Response to WSCC - Summer Lane, Pagham

1. This note has been prepared by Vectos in response to WSCC's comments on the Transport Statement (TS) in support of the erection of 90 dwellings with associated access and open space at Summer Lane, Pagham (Planning ref: P/58/15/OUT).
2. This note presents WSCC's comments in their entirety before providing a response.

Key:
Ex:16.71m Existing Visibility
Pr:16.71m Proposed Visibility

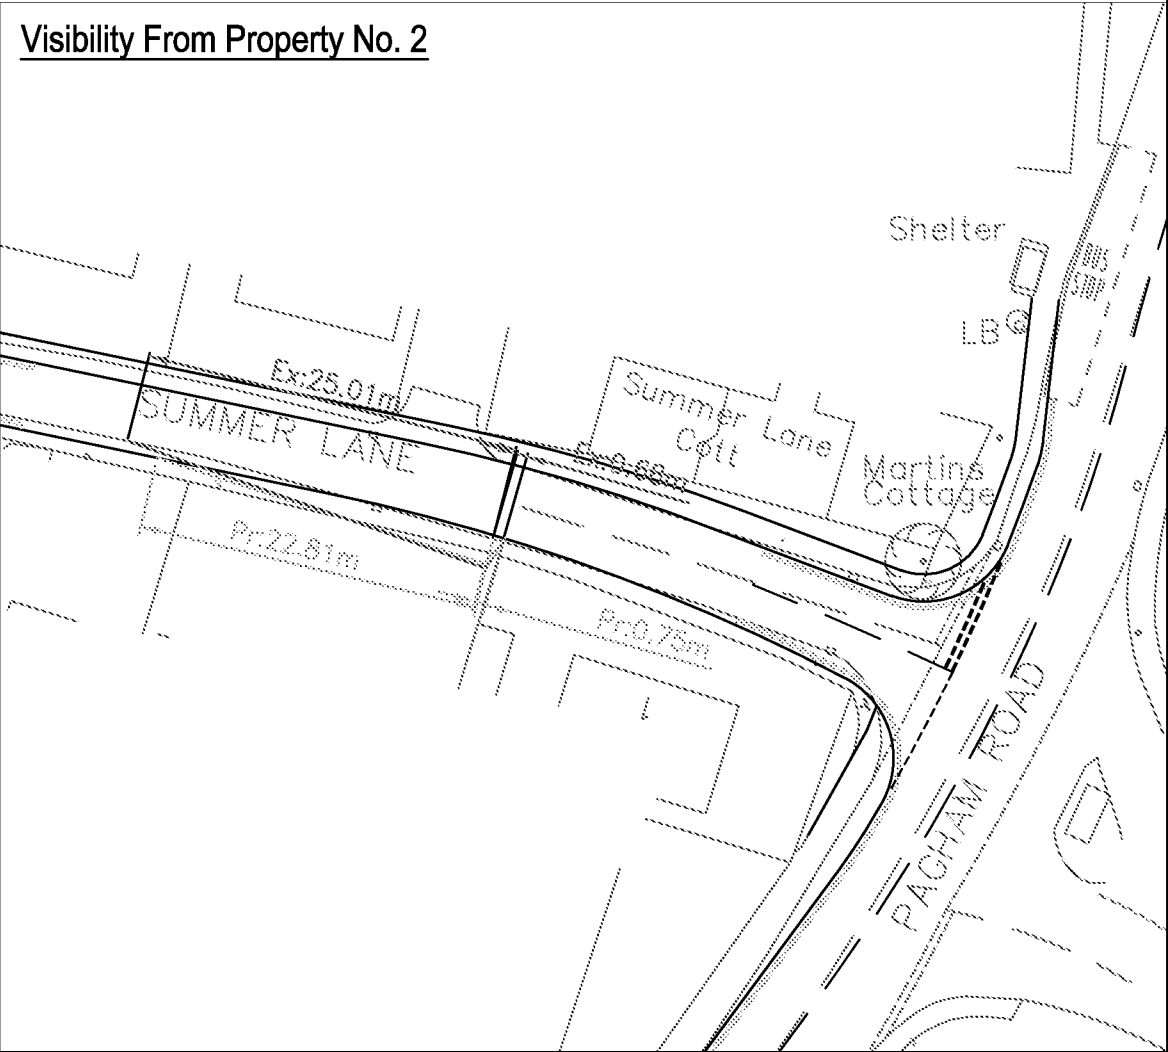
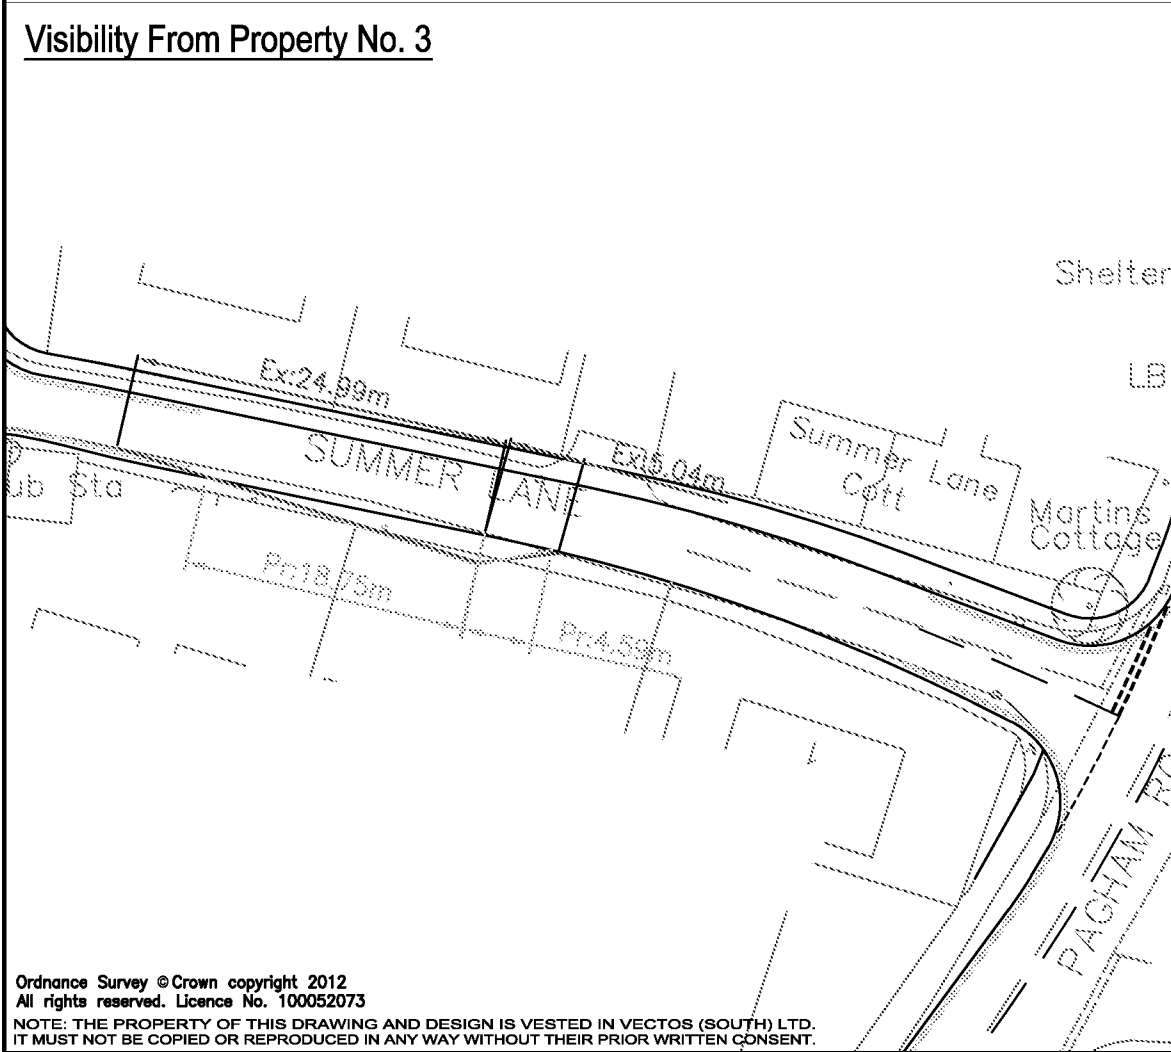
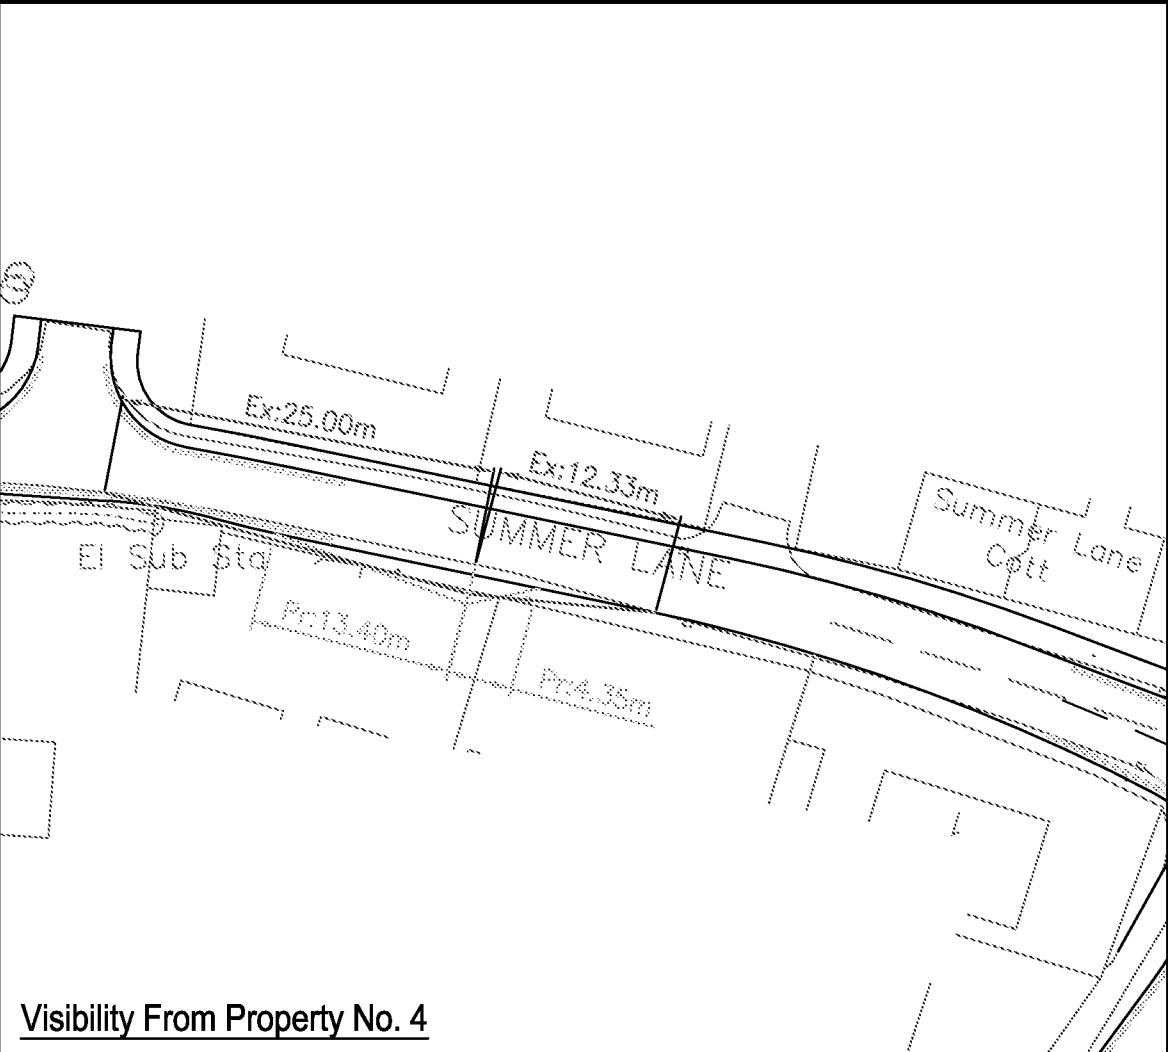
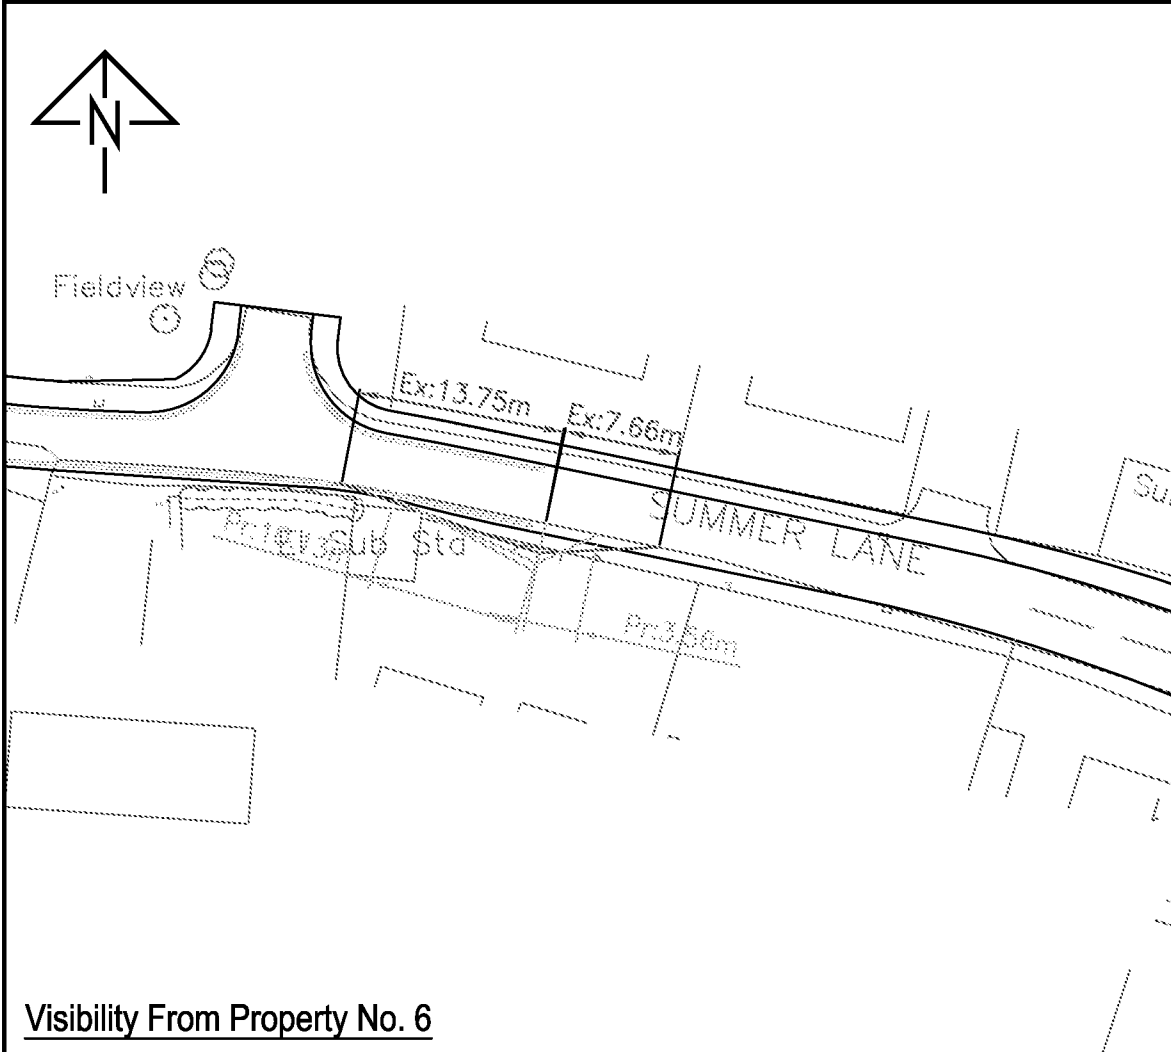
The arrangement shown would also involve relocating the existing narrow footway from the southern side of Summer Lane to the north. In principle, there would be benefit to this given the widening of the footway that would result. Removing the footway from the southern side of the carriageway may have consequences for visibility from the accesses for those existing dwellings. It would appear that visibility may be substandard based on the existing arrangements, the proposed works would potentially worsen matters. Again, this matter should be appropriately considered with it determined how much of an impact would result from relocating the footway.”

5. A comparison of visibility splays has been carried out to assess the impact of relocating the footway. For the effected dwellings, existing visibility splays and proposed visibility splays are shown in drawing 120843/SK/13 Rev A. As mentioned above the removal of the southern footpath does reduce visibility for residents. The worst reduction in visibility is 7.98m from 12.33m to 4.35m. Visibility splays have been produced to show a worst case scenario by adhering to property boundaries. However in reality visibility will be unobstructed due to low level vegetation on property boundaries and will therefore effective visibility will be similar to existing levels.

6. Following initial comments from WSCC, a short stretch of Summer Lane the carriageway has been narrowed to 4.5m and the footway has been narrowed to 1.5m. This improves visibility for properties along Summer Lane once the footway has been moved to the northern side of the road. It is worth noting that while visibility for properties along the southern side of Summer Lane may be reduced, visibility for properties along the north side of Summer Lane will be increased. Drawing 120843/SK/14 Rev A shows the increase in visibility for the properties along the northern side of the road. The biggest increase in visibility is from Shelig, where visibility has increased from 4.64m to beyond 25m.

DRAWING NUMBER:	120843/AT/A01	REVISION:	A
-----------------	---------------	-----------	---

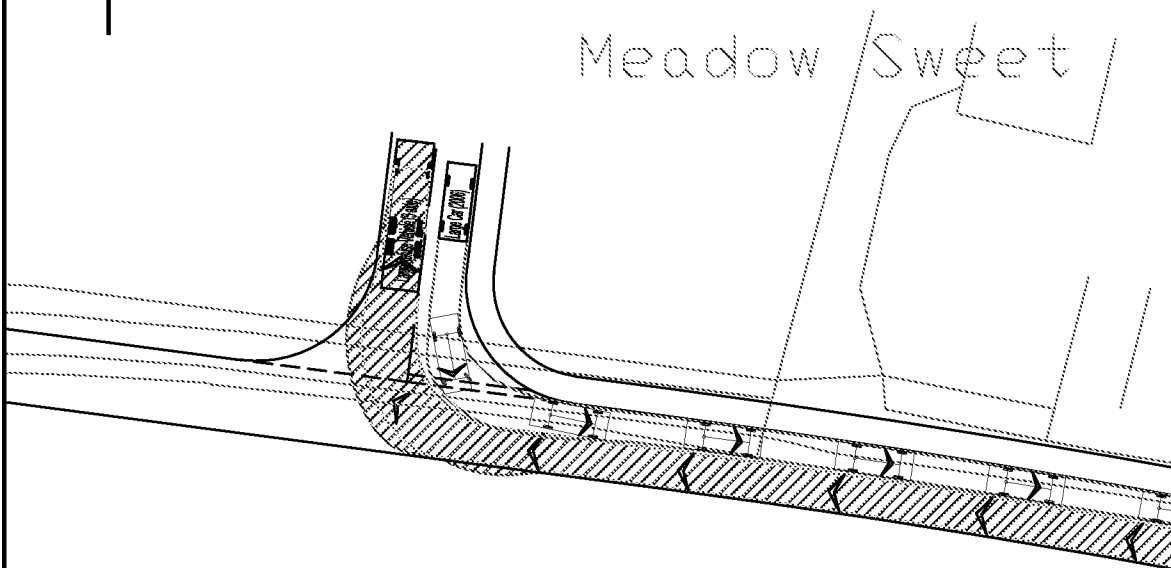
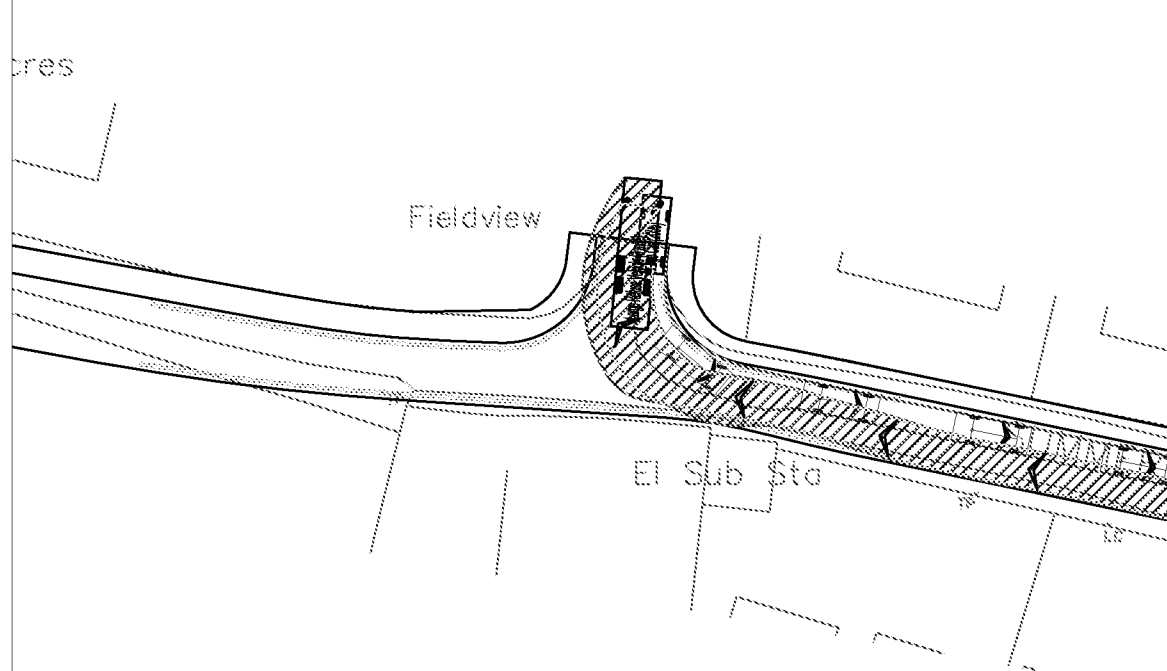
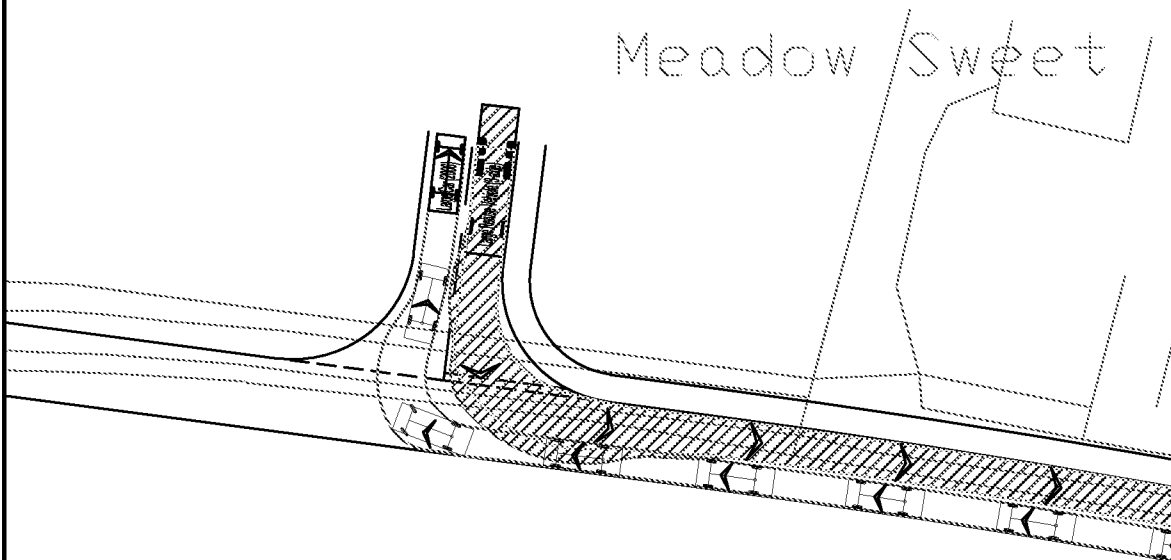
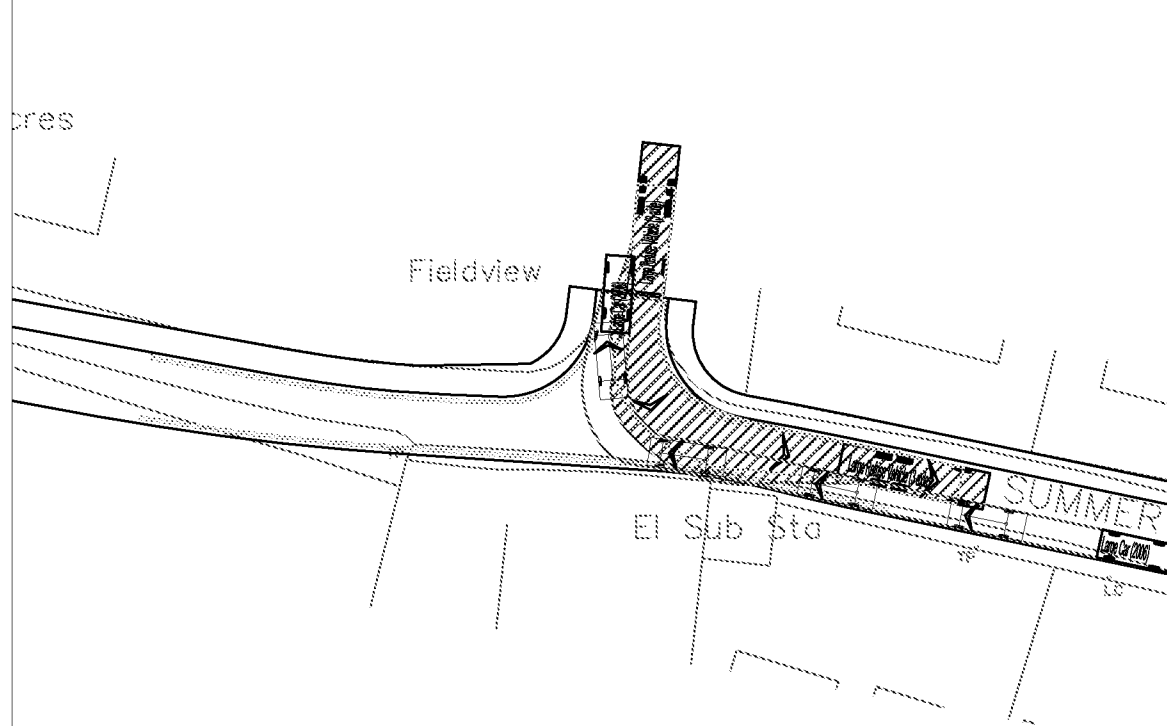
“No swept paths have been provided at the access points. This is especially pertinent given the narrow carriageway width in the vicinity of the eastern access. The applicant was advised at the pre application stage to consider narrowing the proposed footway to enable localised carriageway widening. Swept paths would need to be provided and the carriageway width revisited accordingly.”

8. Swept paths of a refuse vehicle passing a car at the eastern and western Summer Lane junctions are shown in drawing 120843/AT/A01 Rev A at the end of this report. The drawing shows that there will be no issues with an outbound car passing an inbound refuse vehicle at the eastern access or an inbound car passing an outbound refuse vehicle at the western access. However there are issues with the reverse arrangements at both junctions. These issues are common in urban areas, requiring one vehicle to give-way to the other. They will also only occur once per week. This is not considered to be a significant issue.
